Project# PR-2018-001579
Application#
SD-2021-00073 PRELIMINARY/FINAL PLAT

PARCEL E-1-A, WINROCK CENTER ADDITION
zoned MX-M, located on **INDIAN SCHOOL RD**
between WINROCK LOOP and
PENNSYLVANIA AVE, containing
approximately 3.38 acre(s). (J-19)

ABCWUA April 14, 2021 Comments:

SD-2021-00073 – PRELIMINARY/FINAL PLAT (3.38 acres)

**ABCWUA EASEMENT**  
 EXISTING ABCWUA  
 WATERLINE EASEMENT  
 SCALE: 1" = 50'

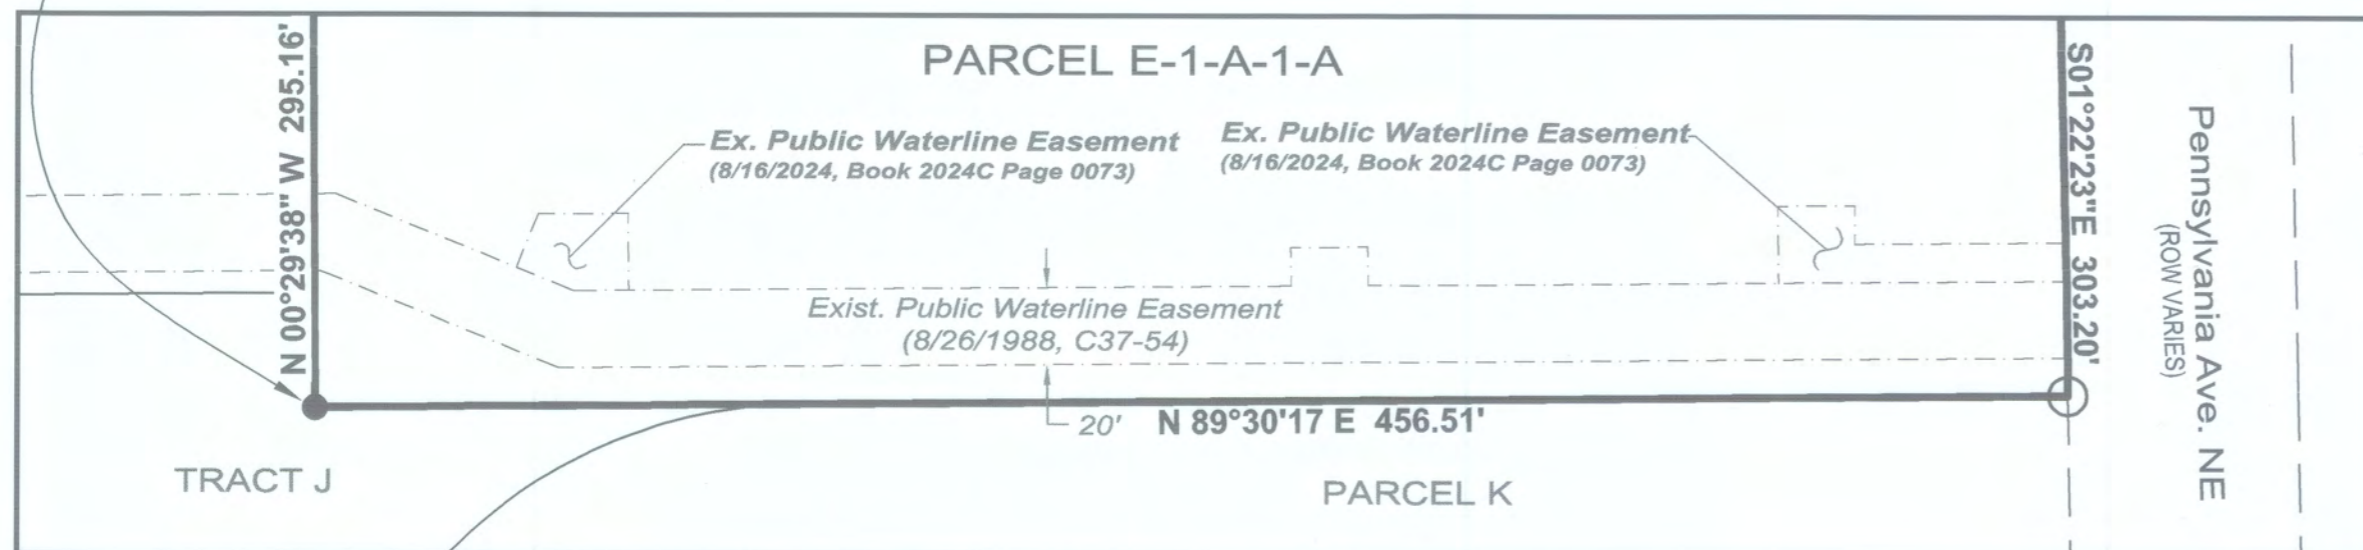
- a. Availability statement #201105 has been issued and provides the conditions for service.
- b. Please reference recording information for existing onsite public waterline easement.

- i. Please detail (dimension arrows) the limits near the southwest corner where the easement bends.
- c. The proposed public sanitary sewer easement shall read as follows: “Public sanitary sewer easement granted to the Water Authority”.

- i. Given that it varies, be sure to dimension the continuous width and detail varied portion with bearings/distances.
 - ii. A minimum width of 20’ is needed for a single utility and 25’ when including both waterline and sanitary sewer. Please ensure adequate easement width is provided given this proposed public sanitary sewer easement will be adjacent to the existing onsite public waterline easement.

- d. Plat needs to vacate onsite existing private sanitary sewer easement that is currently serving the existing townhomes within existing Lot K. How will the timing of its abandonment and construction of new public sanitary sewer affect this action given that this private sanitary sewer service needs to remain in place and the existing easement preserves this private sanitary sewer service?

- e. Please provide bearings/distances to detail proposed waterline easements.
- f. It is understood that the existing public waterline will be relocated due to the location of the proposed trash enclosure/compactor. Please vacate the portion of waterline easement and grant new public waterline easement, accordingly.
